15 Rose Street
Chatswood NSW 2067
19 September 2012

PROPOSED DEVELOPMENT OF "THE BLOCK" IN REDFERN

4 Caroline Lane  
1 : 200

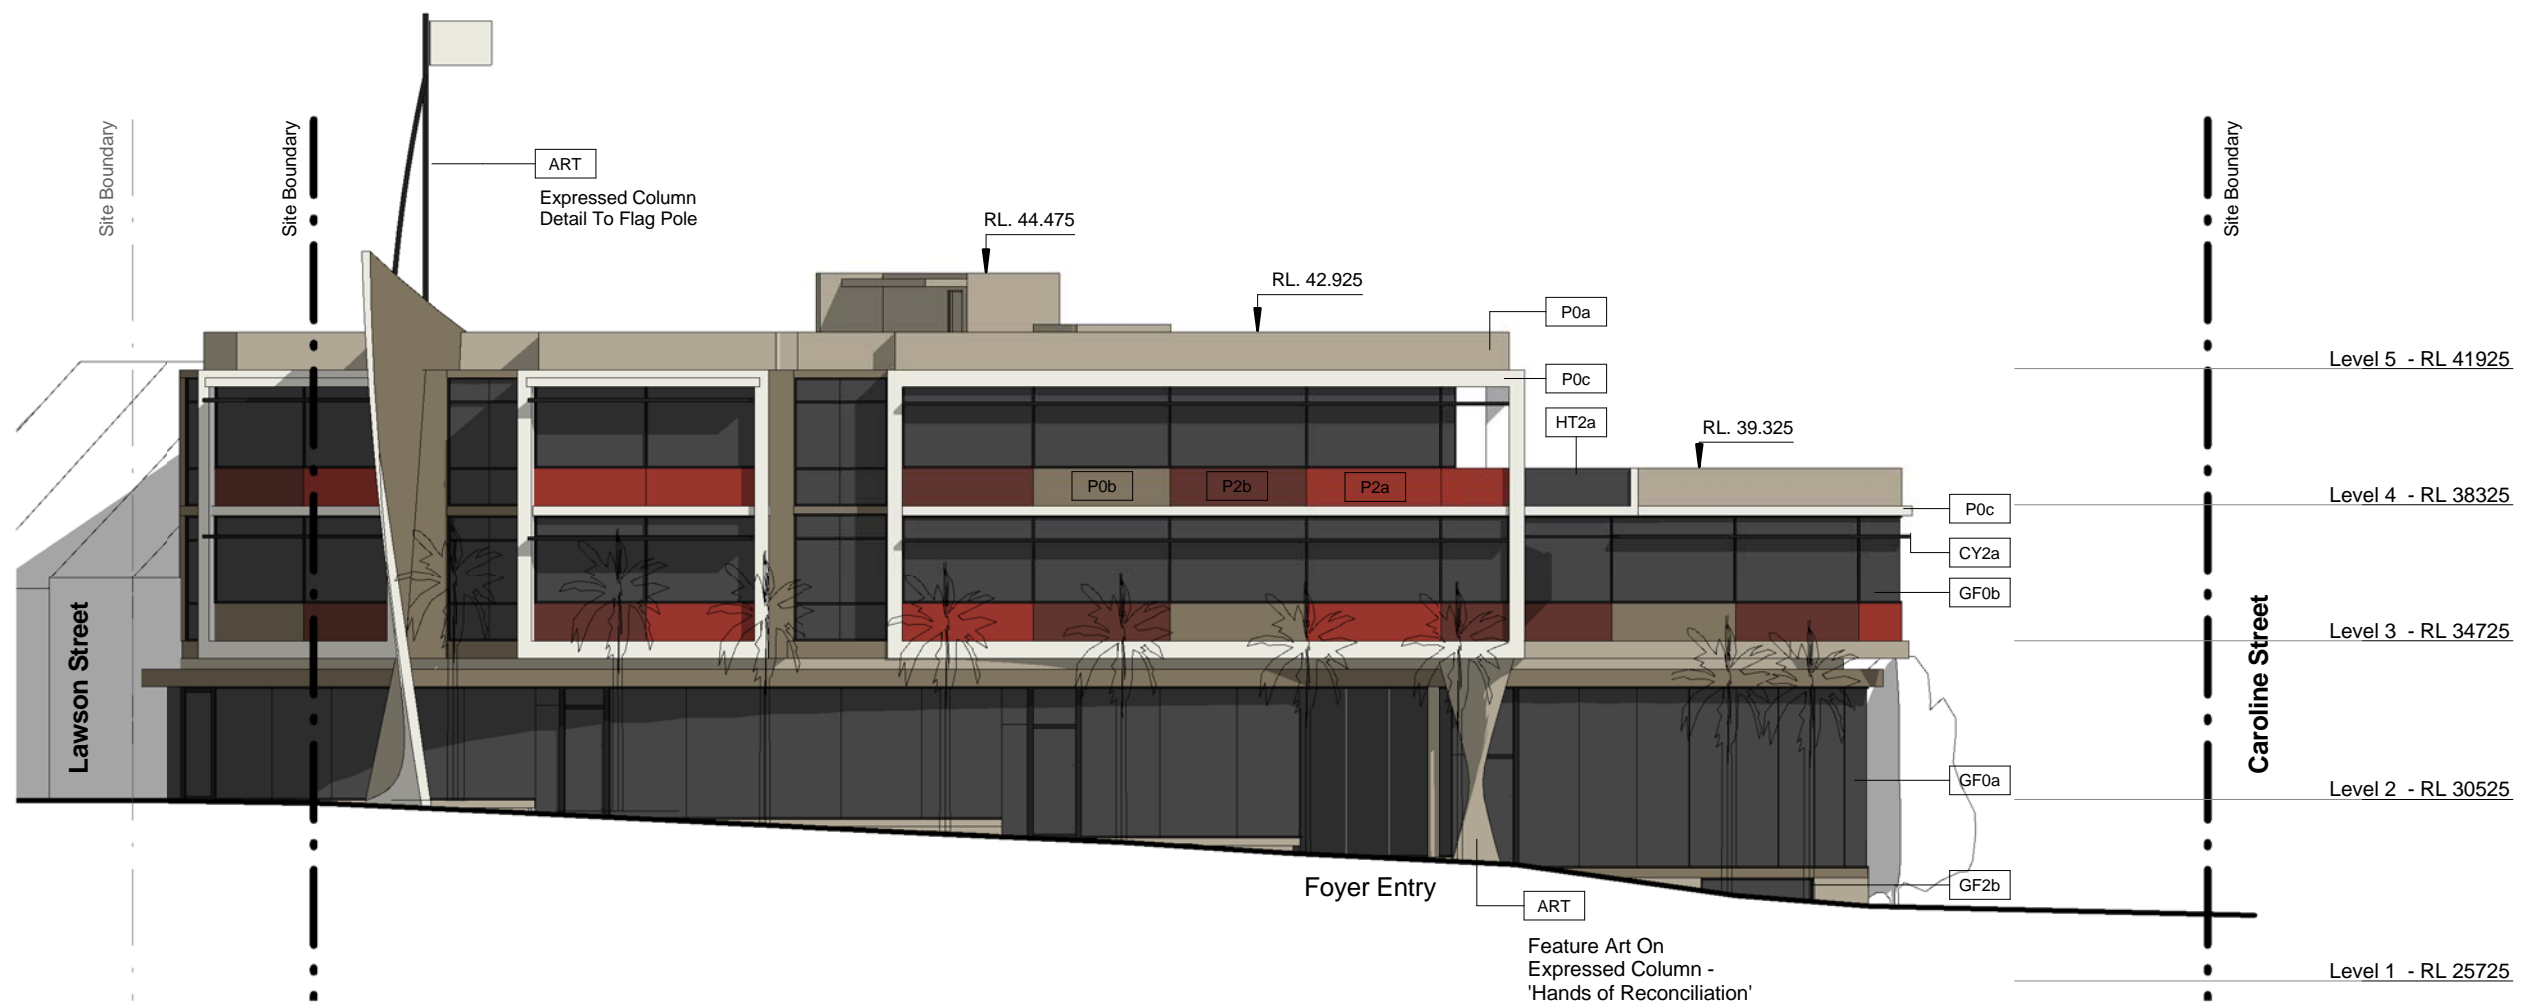
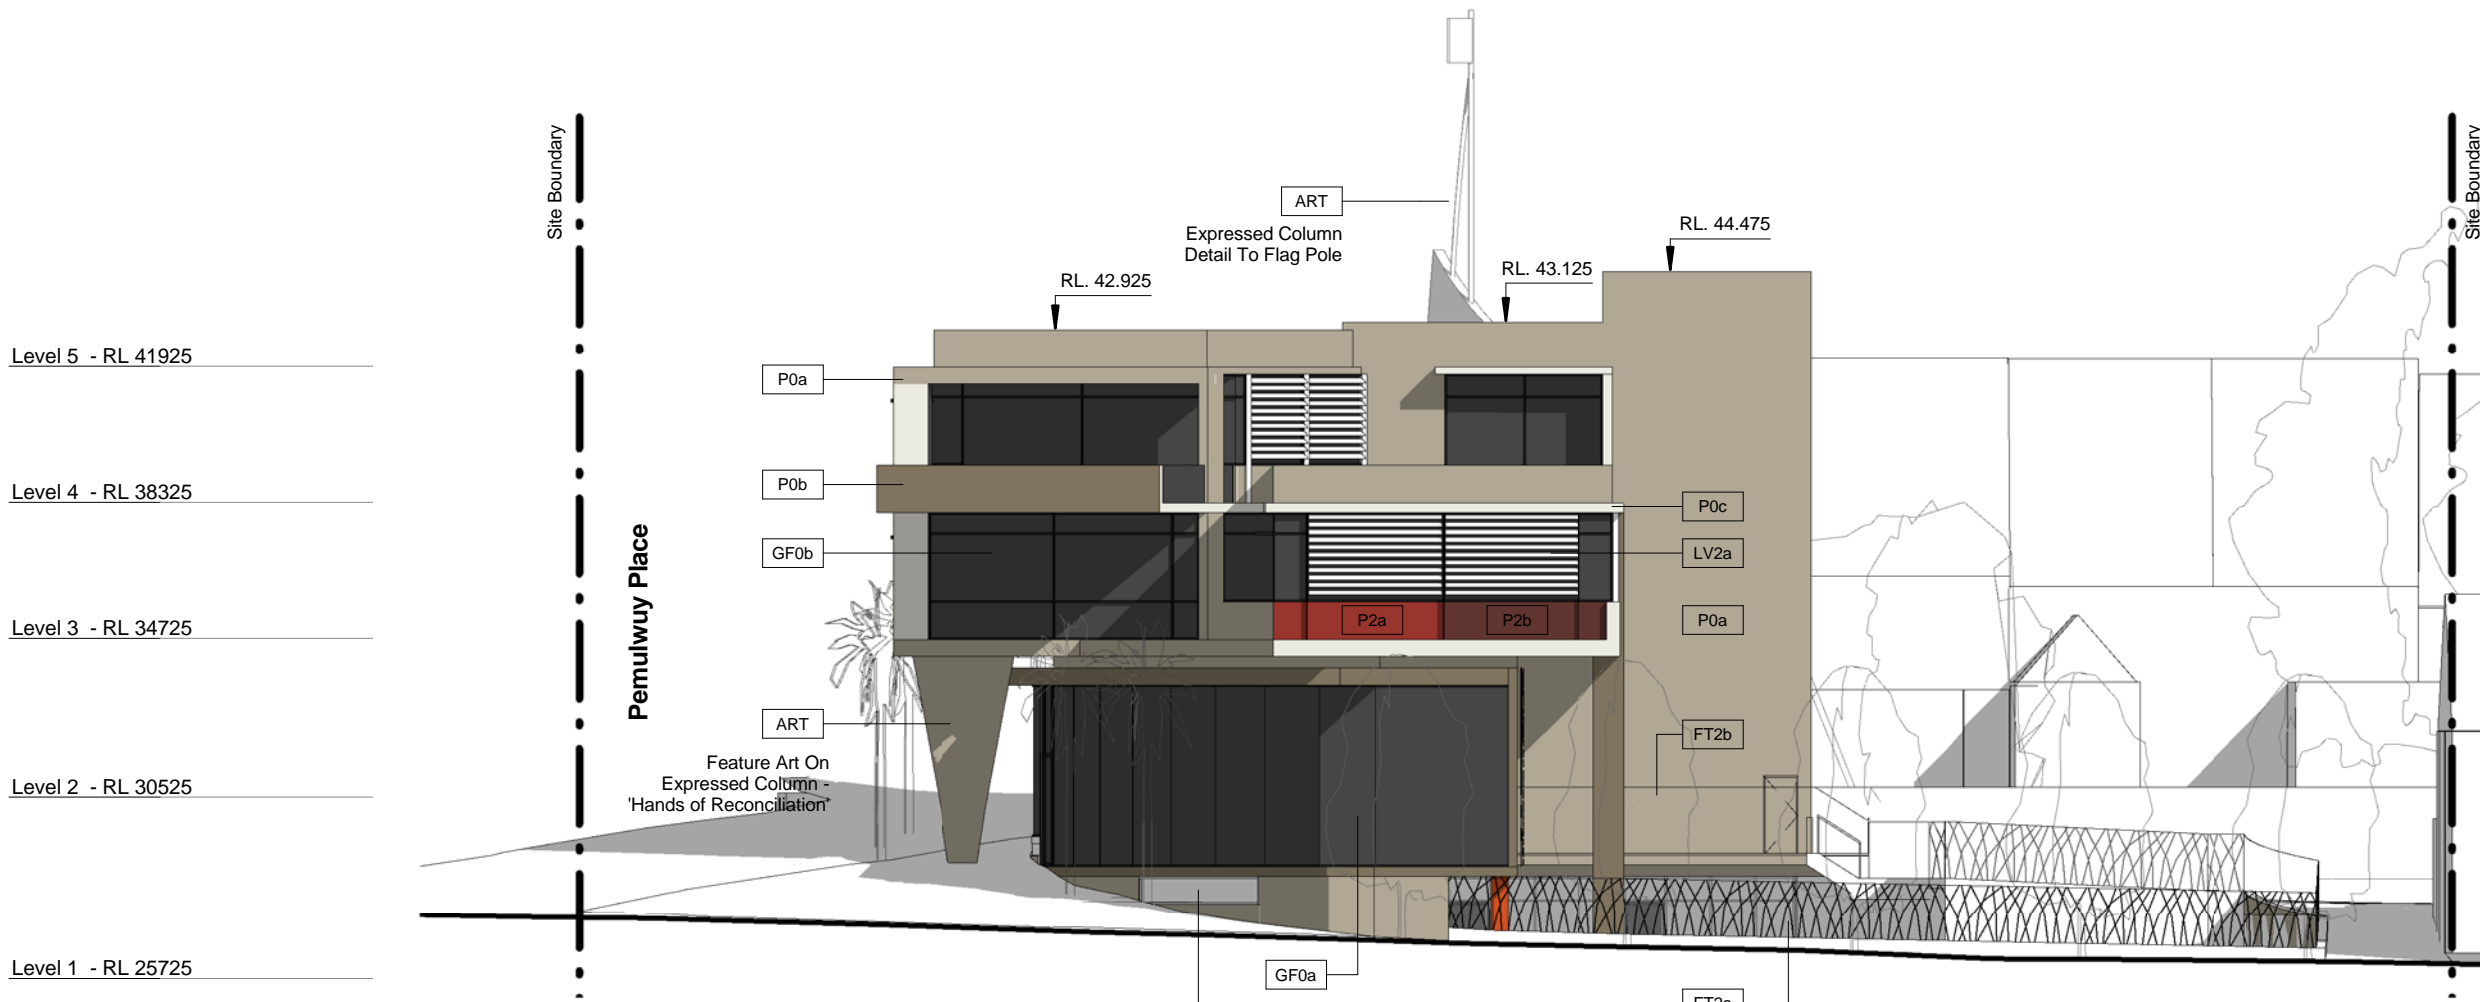
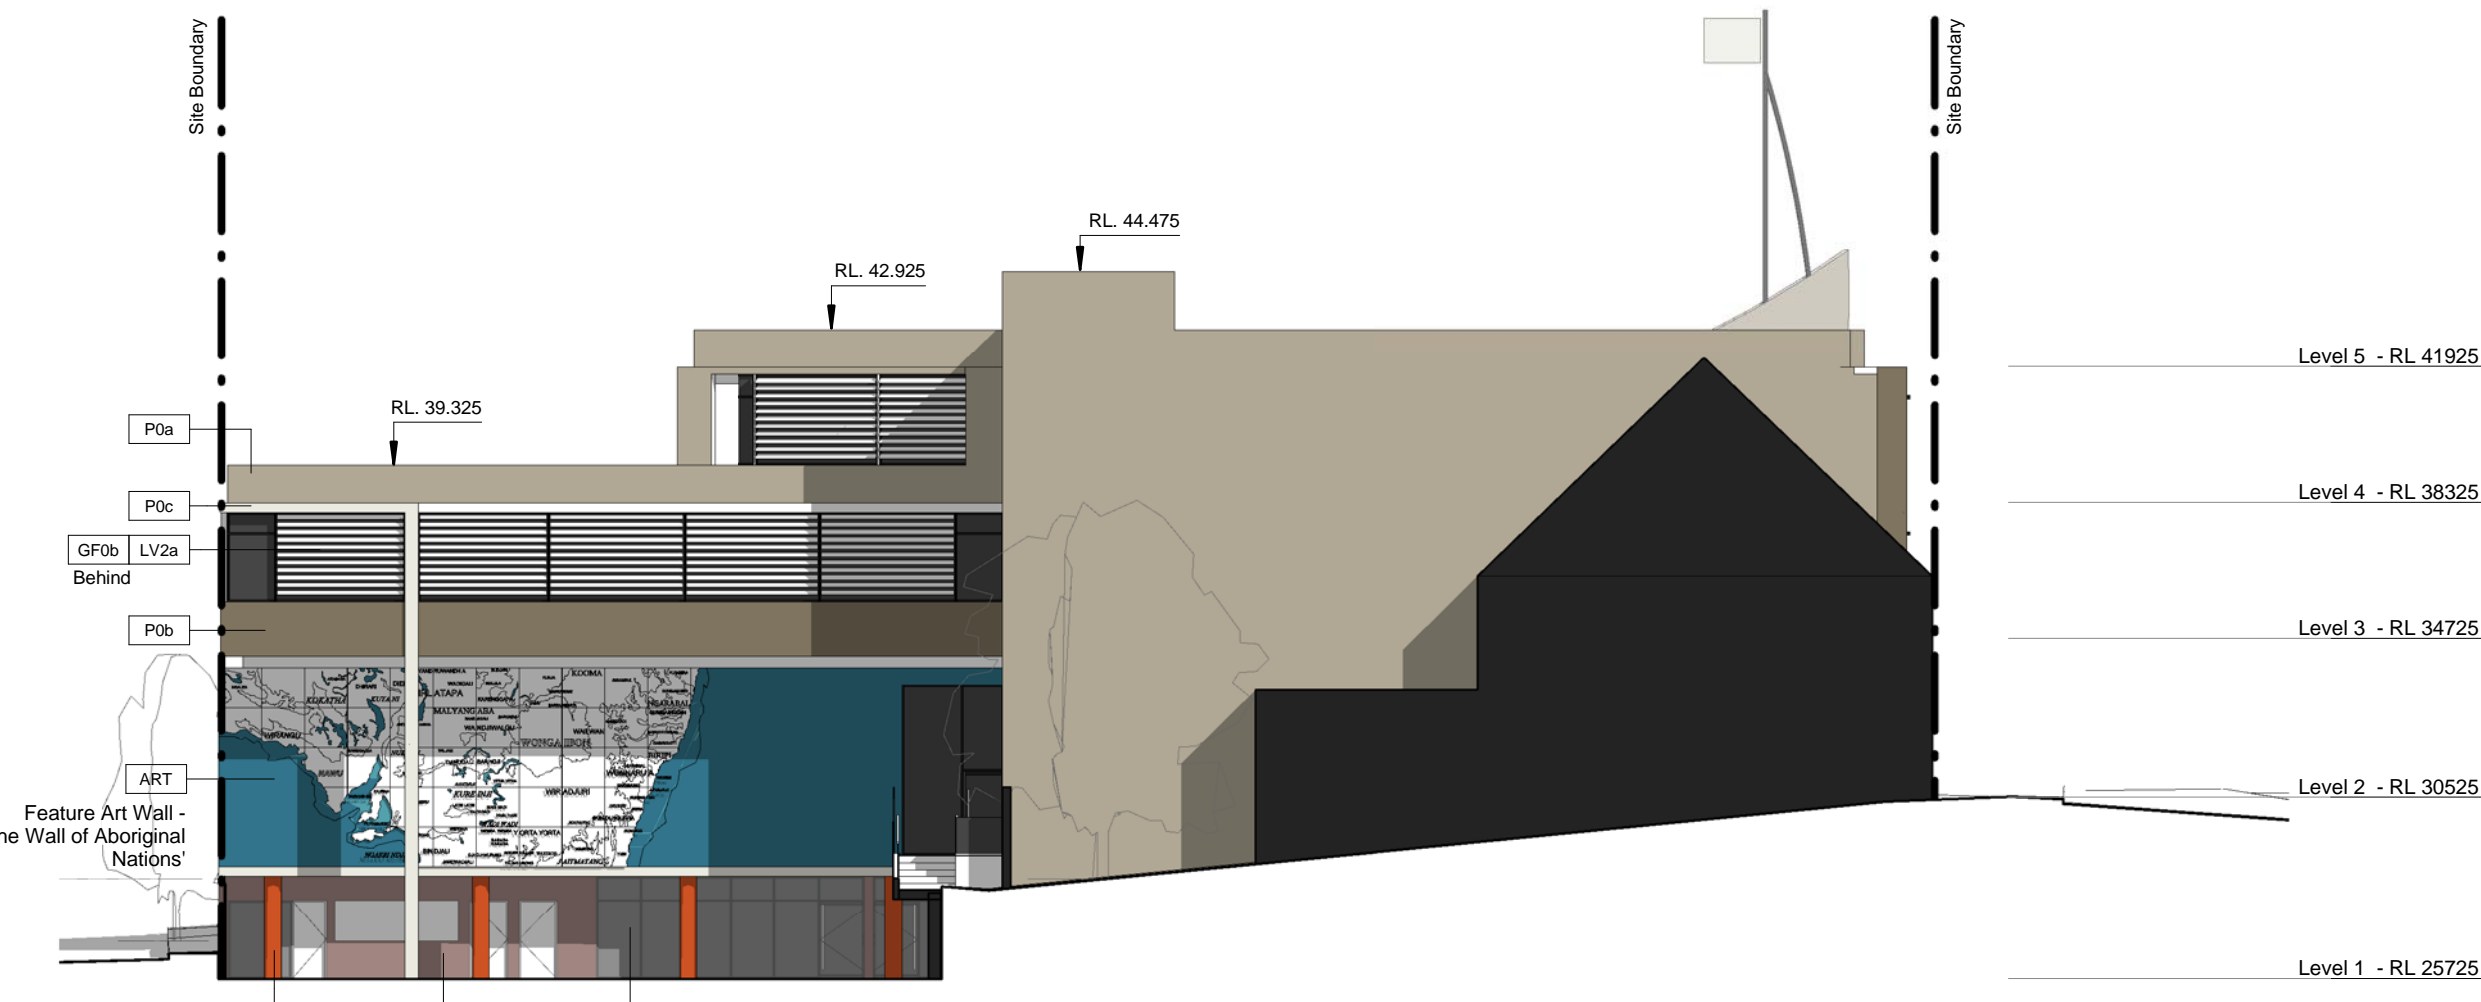
The plans prepared by Nordon Jago show the B99 vehicle turning the T junction intersection and it states that this is the largest car *likely* to use the lane. From my experience, spending a lot of time at the rear of my property in Caroline Lane, there is a large variety of vehicles which use the lane, including small trucks and one resident of Lawson Street backing onto the lane has a large ute with trailer. My own vehicle is a 2005 Holden Rodeo Dual Cab with a tray on the back and is 5.3 metres long and I also have parking in Caroline Lane and will be using it every day. The Holden Rodeo has a very bad turning circle and I'm concerned about my ability to exit the proposed lane.

Furthermore, we note that any resident of Lawson Street or indeed Caroline Street who presently wishes to employ a truck for removal of rubbish etc via Caroline Lane can do this using a truck and/or trailer. The proposed bend in the lane, with a turning circle as shown, means that this will no longer be possible, thereby reducing the amenity of Caroline Lane for local residents.

Note that it is also impracticable, and probably dangerous, to reverse any vehicle all the way down the Lane to Abercrombie Street to avoid the bend in the lane.

It is our view that minimum standards have been applied to Caroline Lane (in the case of both the turning circle and the treatment of 108 Lawson Street – see below) at the expense of current residents of Caroline Street and Lawson Street. This is not fair or reasonable and should be addressed.

Accordingly we strongly request that the turning area in Caroline Lane be expanded to allow for larger vehicles.

We note that the rear of 108 Lawson Street will be compromised by the inclusion of a 45 degree angled wall outside the garage. 108 Lawson Street is the last privately owned property in the row of terraces before the properties which are subject to the development proposal, and as a consequence is the only privately owned property adjoining the proposed development. According to Greg Colbran, the property developer, the original plan showed a squared off rear of 108 Lawson Street, but this has been changed as a result of advice from the traffic consultant to the effect that "as long as a Tarago can enter and exit 108 Lawson Street then that is all that is required".

The problem is that the triangle of land, measuring only approx. 4.5 square metres, which has been taken from the existing lane will form stairs taking pedestrians from the Caroline Lane level up to the retail level above. This configuration allows a pedestrian a full view over the back fence of 108 Lawson Street and into the back yard. As a result the amenity of the back yard of 108 Lawson Street

is highly compromised, and yet the proposed development only gains to the extent of a mere 4.5 square metres.

Accordingly we strongly request that the plans be amended to provide full access to the garage of 108 Lawson Street rather than the currently proposed 45 degree angle entry and exit
